Your ref: 24.0321  
Our ref: D3.24.0321  
Date: 27<sup>th</sup> June 2024

**App no: 24.0321**

**Proposal: Advertisement consent for regularisation of five unauthorised, illuminated steel directional signs with vinyl banners and wooden posts 1m high 1.4m wide x 2.1m long**

Vega

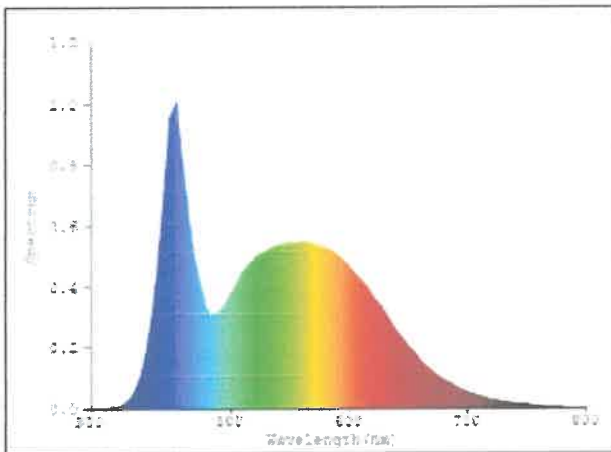
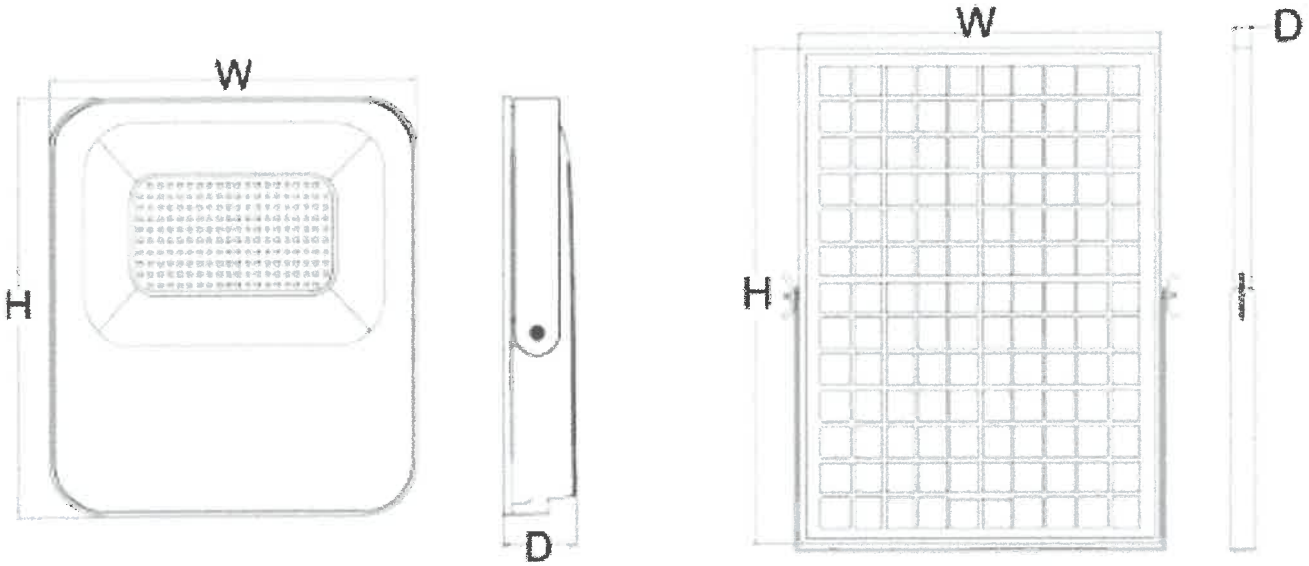
The illumination details are insufficient to allow comments to be made.
